RFI

RFI #: 25
 Date: 1/5/2012
 Job: EB-02 Keller Springs Lofts
 Phone: 877-777-5115

CC:
 Subject: L shaped rebar dowels

TYPICAL PIT WALL SECTION
NO SCALE

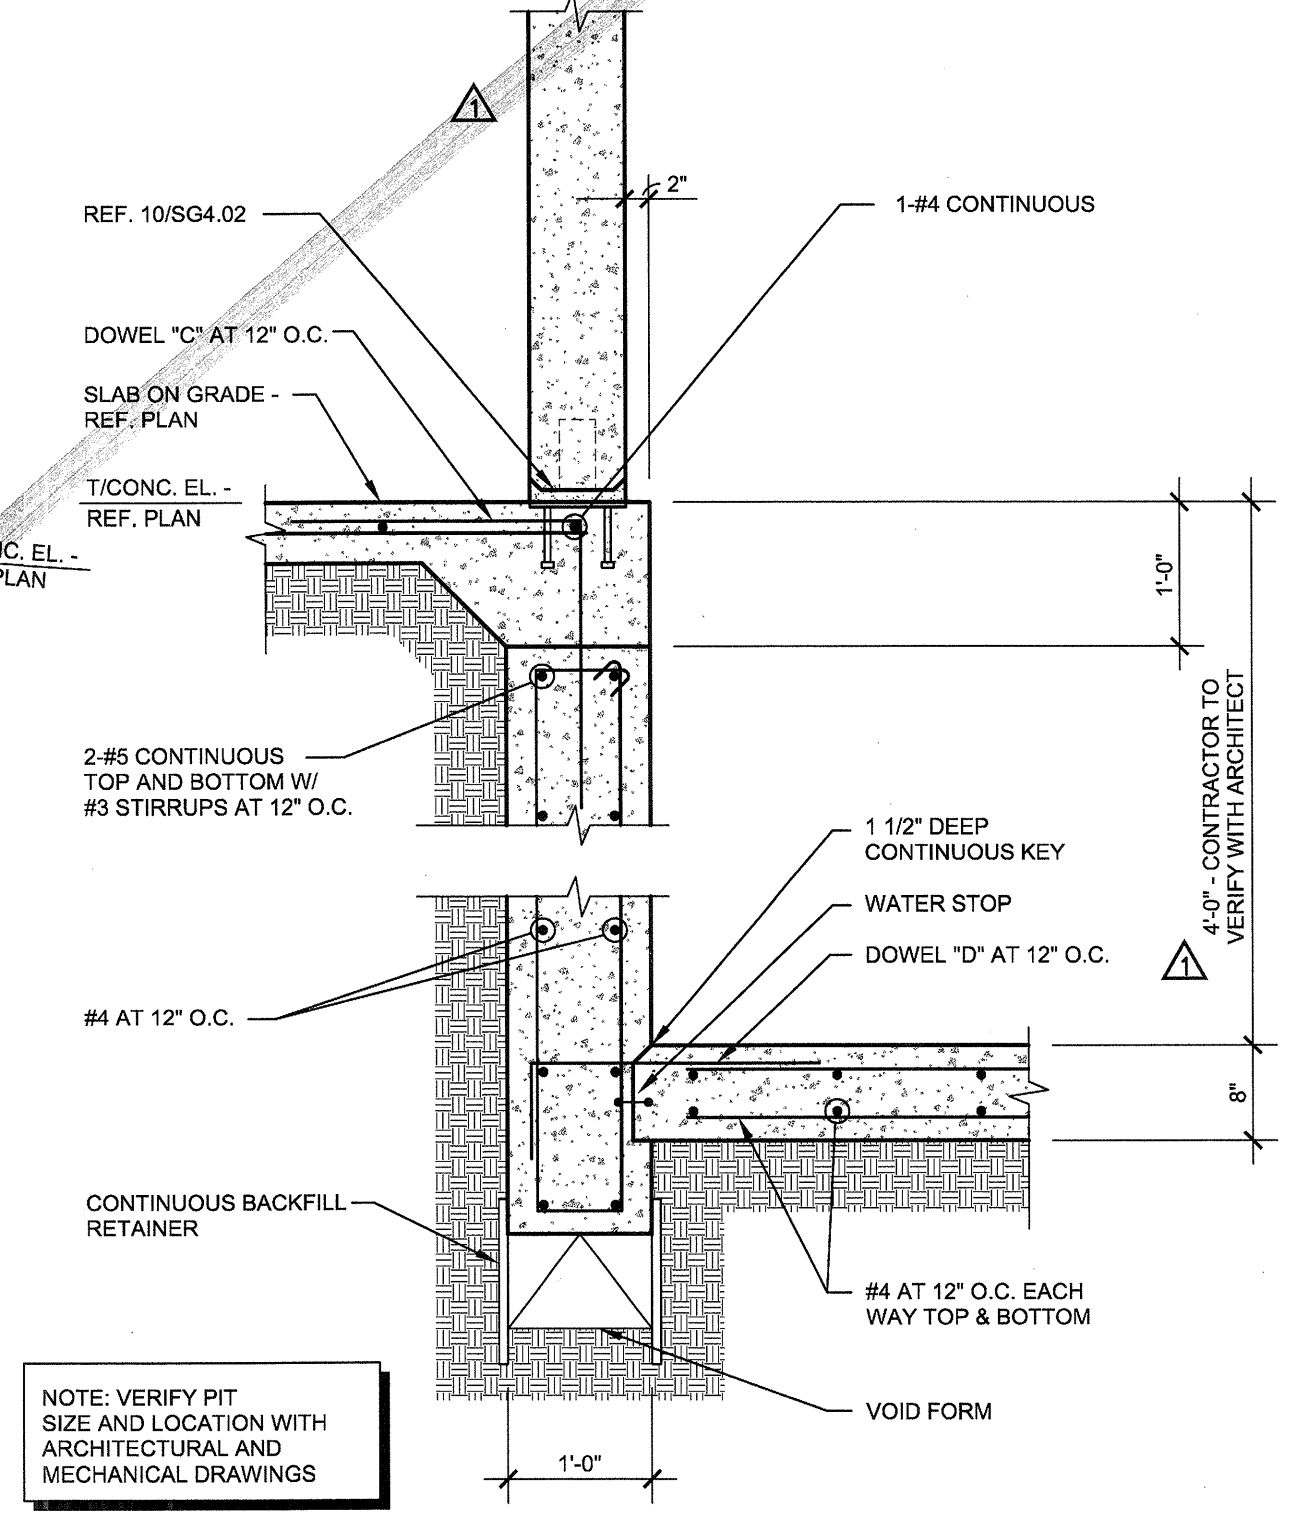
Request:
 Detail 4/SG3.02 and 5/SG3.02 shows rebar dowels from beam walls to the F.F. slab of garage floor. Since the beam walls are formed and poured 1st we will not be able to install dowel bar 1st. We would have to destroy the panels if we did. Can we pour the walls 1st and then come back and drill and epoxy the dowel later. Please give us the required information for the depth of drilled dowels and epoxy strength required. Also do you want them to be L-bar with the L side in the slab?
 Date Required: 1/12/2012

Request:
 Is 3/SG3.02 the correct detail @ intersection of grid line 6 + B?
 Date Required: 1/12/2012

Request:
 Detail section 1/SG3.02 shows a 1" thickend beam which partially abuts to the pre-cast panel and beam wall. However, typical T.O.W elevation is 1' below the typical top of F.F. for garage slab. Therefore the beam and the pre-cast panel will be recessed 1" from top of F.F. garage and several feet from top of F.F. of building slab. Please advise
 Date Required: 1/12/2012

Request:
 As previously discussed, there was a question in regards to the number of L-bars from top of pier and into the pier cap. Our concrete man felt that detail 3/SG3.02 was calling for (2) #7 L-bar dowels (one on each side of column). We found out there were six L-bars supposed to be coming from the pier cap. What is the fix for the piers already poured?
 Date Required: 2/16/2012

Response:
 It is acceptable to drill and epoxy grout the dowels. Dowels shall be the same size indicated on the drawings and a minimum of 2'-0" in length. The embedment shall be 6" minimum. Adhesive shall be in accordance with the Adhesive and Drill-In Anchor Notes on sheet S1.01 of the structural drawings. The L-bars may be used; however, straight bars are acceptable.
 If you have questions or require additional information regarding this matter, please do not hesitate to contact us.

Response:
 Please refer to revised drawings issued on January 25, 2012. If you have questions or require additional information regarding this matter, please do not hesitate to contact us.

Response:
 Refer to structural drawings issued on January 4, 2012.
 If you have questions or require additional information regarding this matter, please do not hesitate to contact us.

Response:
 Drill and grout in additional dowels as required utilizing Simpson SET adhesive with a minimum of 13 1/8" of embedment in accordance with the recommendations of the manufacturer.
 R. Trent Perkins, P.E.
 Parkin-Perkins-Olsen Consulting Engineering, Inc.
 February 15, 2012
